Charlotte Department of Transportation

Memorandum

Subject: Rezoning Petition 08-039: Located on the southeast corner of Providence Road and Alexander Road (revised 2/18/08)

Scale:	1" = 30'
Date:	7 NOV 2007
Project No.:	263-001
Revisions:	1. 2-18-08 PER CMPC COMMENTS
Sheet	L-1

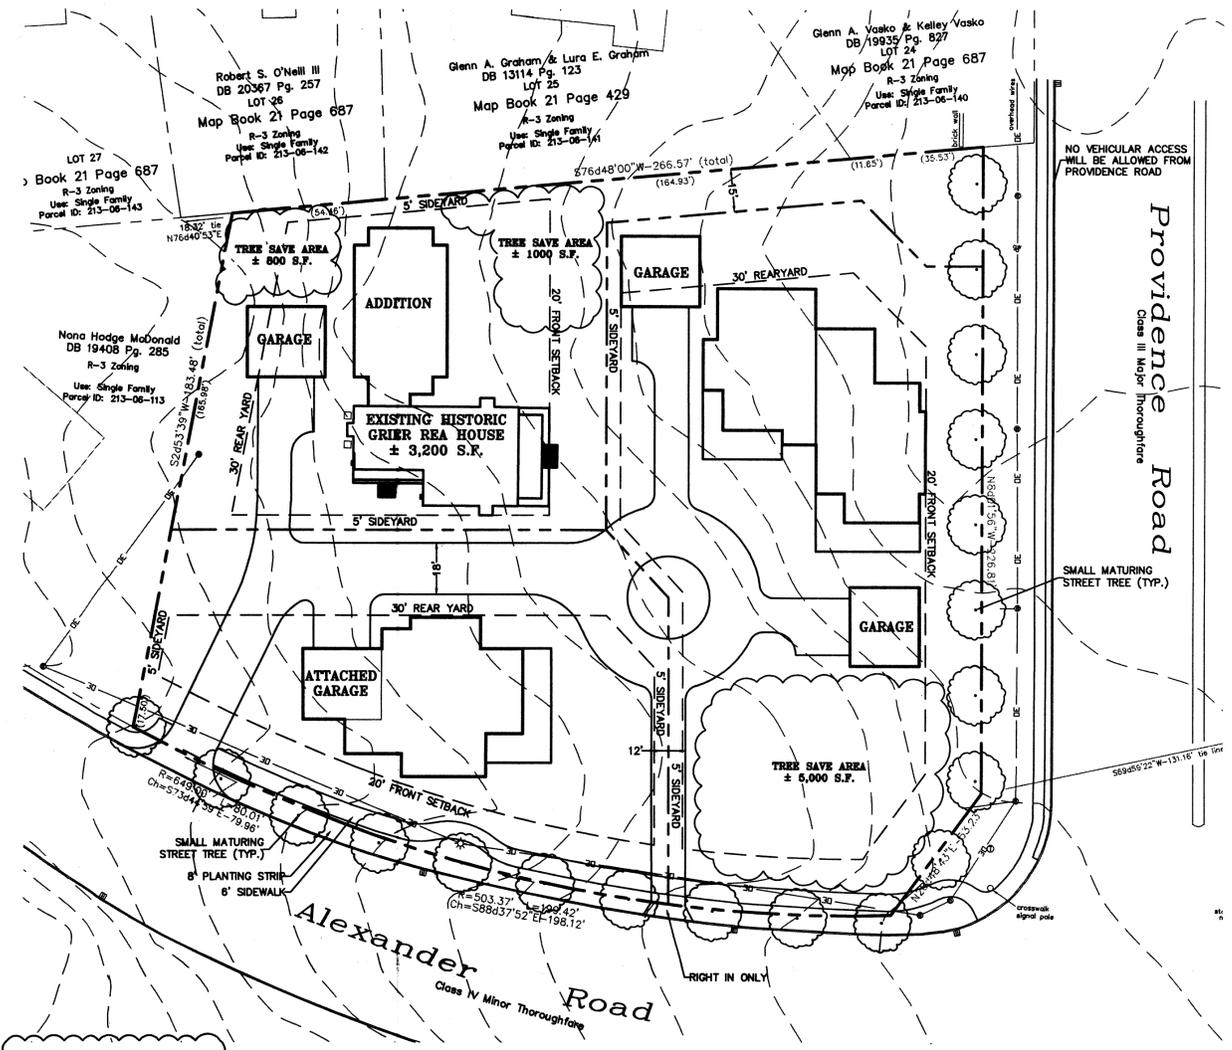
1. The petitioner needs to replace existing sub-standard sidewalks along Providence Road with 6-foot sidewalks and 8-foot planting strips, as well as directional ramps (two per corner) at the intersection of Alexander and Providence Roads. (*Previous review comment*)
2. The petitioner needs to eliminate the driveway closest to Providence Road, retaining only one driveway on Alexander Road. (*Previous review comment*)

Alexander Road is a minor thoroughfare requiring more than the minimum 70 feet of right of way in order to include the entire planting strip within the right-of-way. The developer/petitioner should convey right-of-way in fee simple title to meet this requirement.
(Previous review comment)
